APPLICATION NUMBER 3/2012/0525
FELLVIEW BARN, BAYGATE, BOLTON BY BOWLAND
GRID REFERENCE SD757 497

A planning application has been submitted by Mr David Schofield for the erection of a machinery/ tractor shed. A site visit was made whilst the applicant was present and the information provided at this meeting, together with the written submissions, forms the basis of this appraisal.

It is proposed to erect a building measuring 18.2m x 9.1m, consisting of a six bay steel portal frame with Yorkshire boarding above and a fibre cement sheeted roof. Access into the building is proposed by a single doorway in the southern gable end. The site of the building is shown on the proposed plan; it is situated in a yard area to the west of the house. The building would be used for the storage of machinery.

PROPOSED MACHINERY/TRACTOR SHED

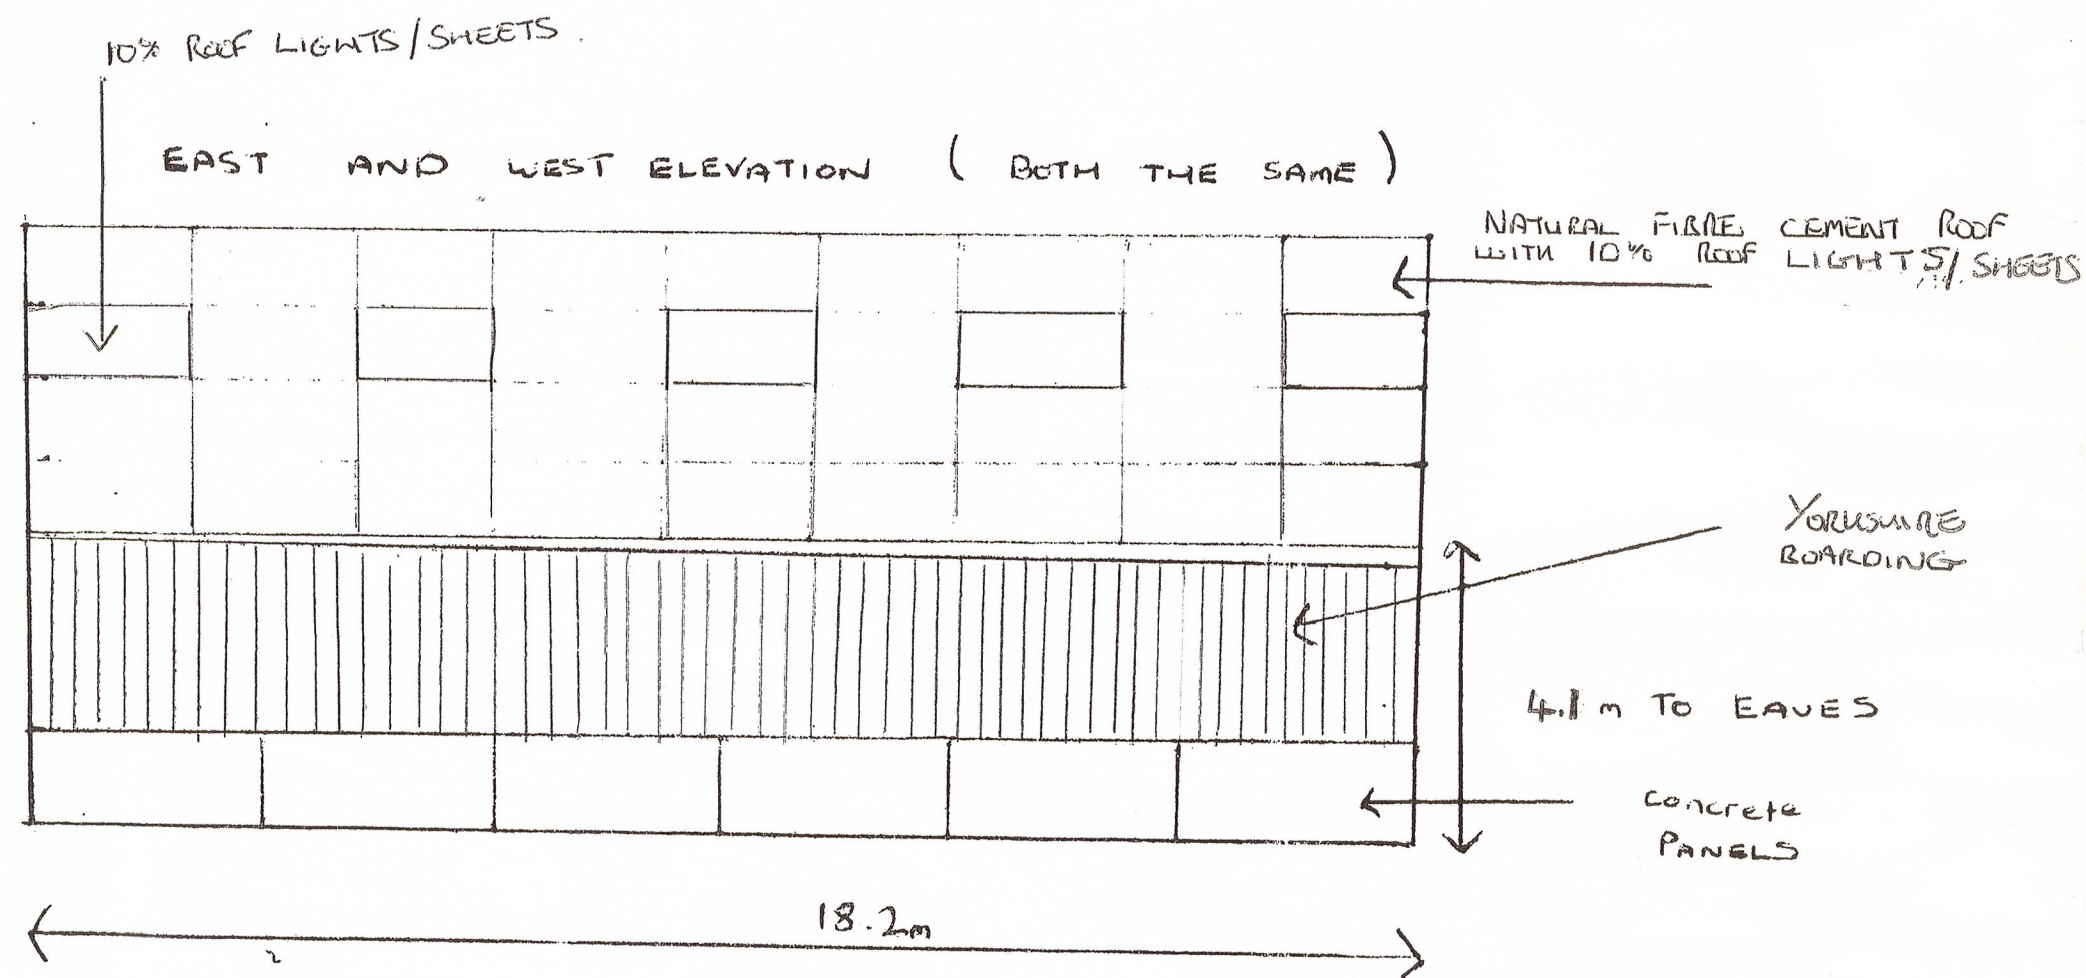
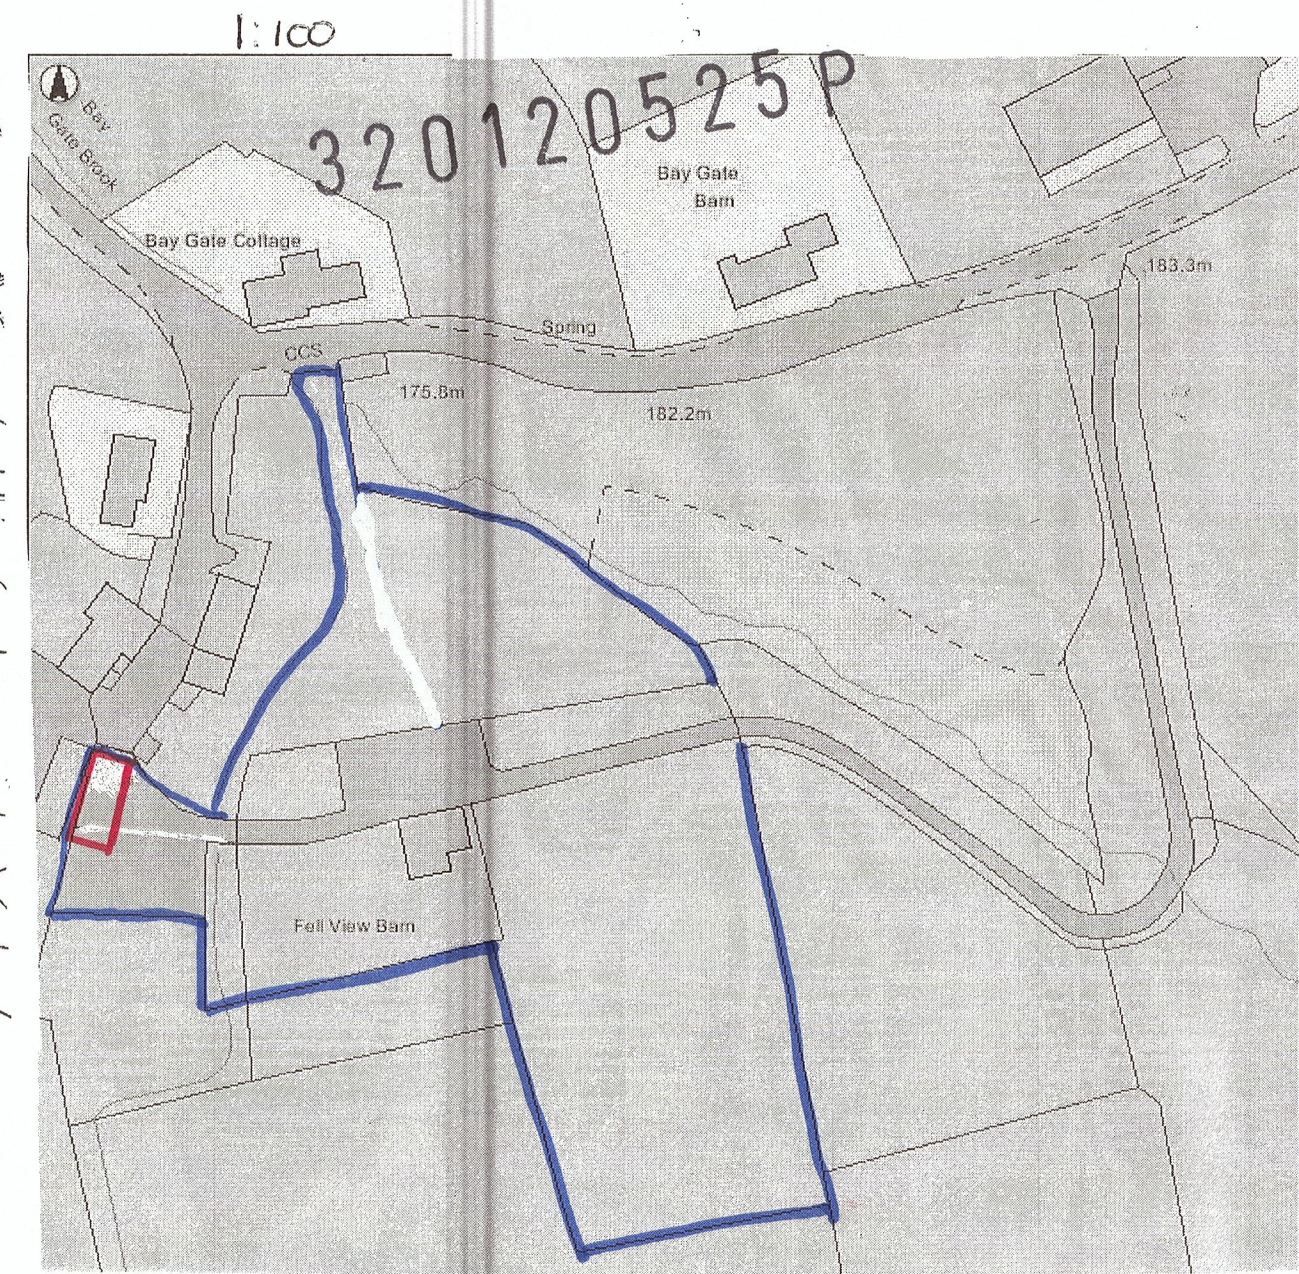
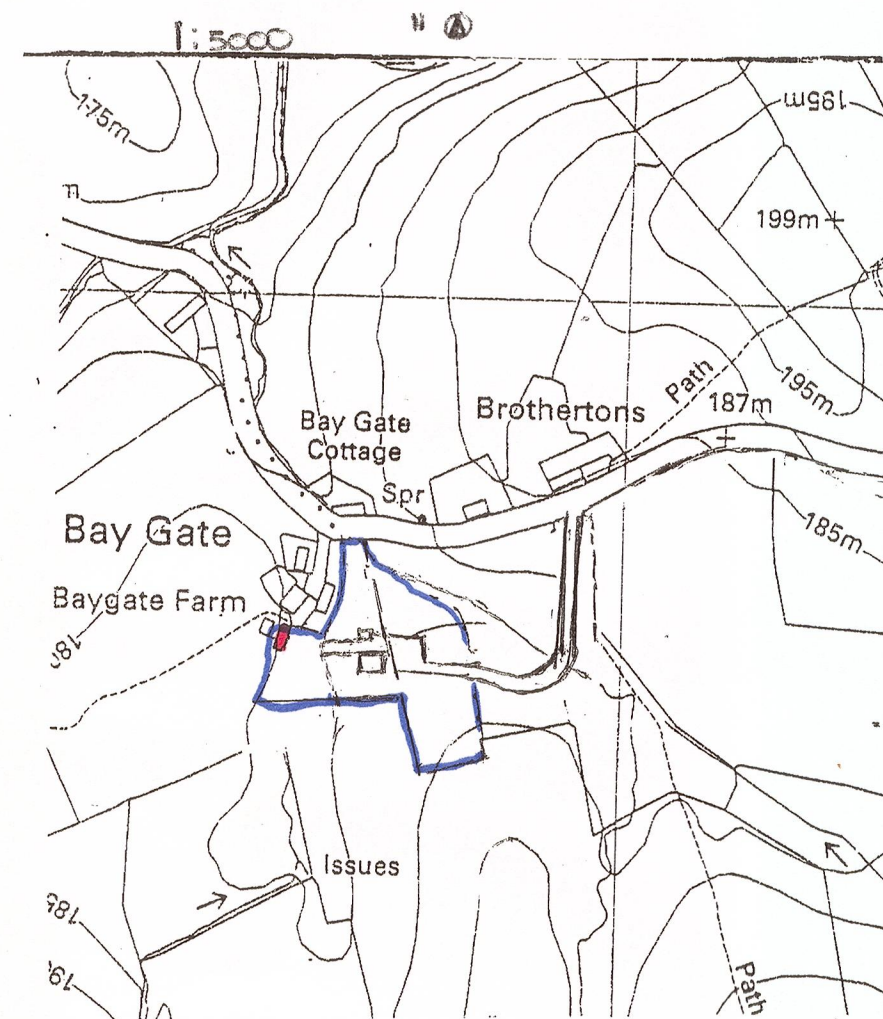
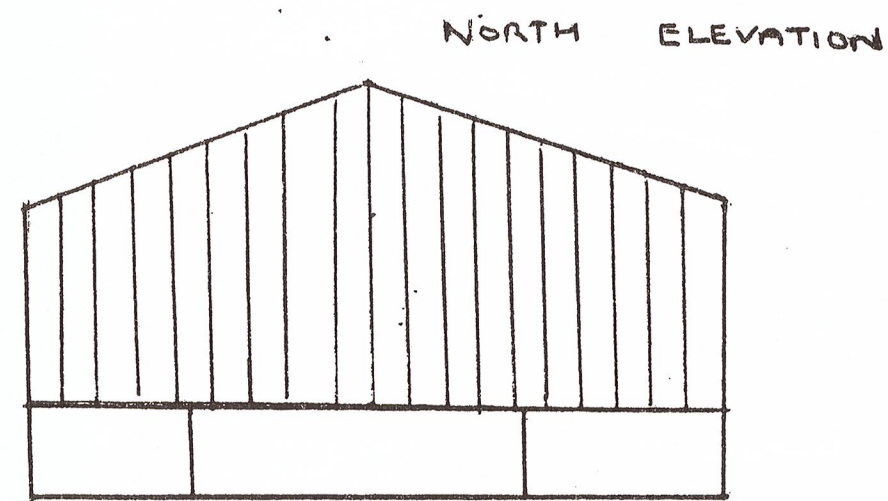
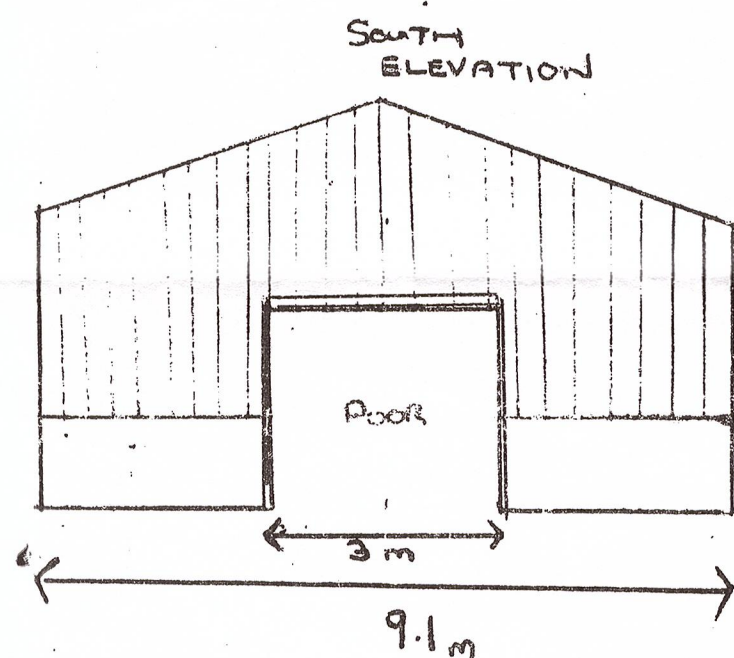
The scale of the proposed agricultural enterprise has not changed from the scale planned when I commented in 2010 and based on this, in my opinion, the applicant already has sufficient space for all of his requirements, including both livestock housing and storage purposes. In particular it should be noted that a large section of the existing building is to be used for lambing purposes, however this will only be required for a small part of the year, and outside this period will be available for general storage.

I therefore do not consider that an additional storage facility is required.

Please note there are two reasons why the applicant considers a separate building to be necessary away from the existing structure. The first is that he considers that the storage of machinery adjacent to livestock housing is not appropriate from an animal welfare perspective. In my mind, I cannot agree that this can warrant a separate building and in my opinion, it is common place for different uses to be carried out within close proximity to each other. The second reason relates to concerns regarding security, in that the site proposed away from the existing building, would provide better security for his machinery, as any visitors would have to pass his house. Whilst I appreciate the applicant's concerns, I am of the view that security provisions could be improved to the existing building / access track, although no doubt you will have your own opinion in this regard.
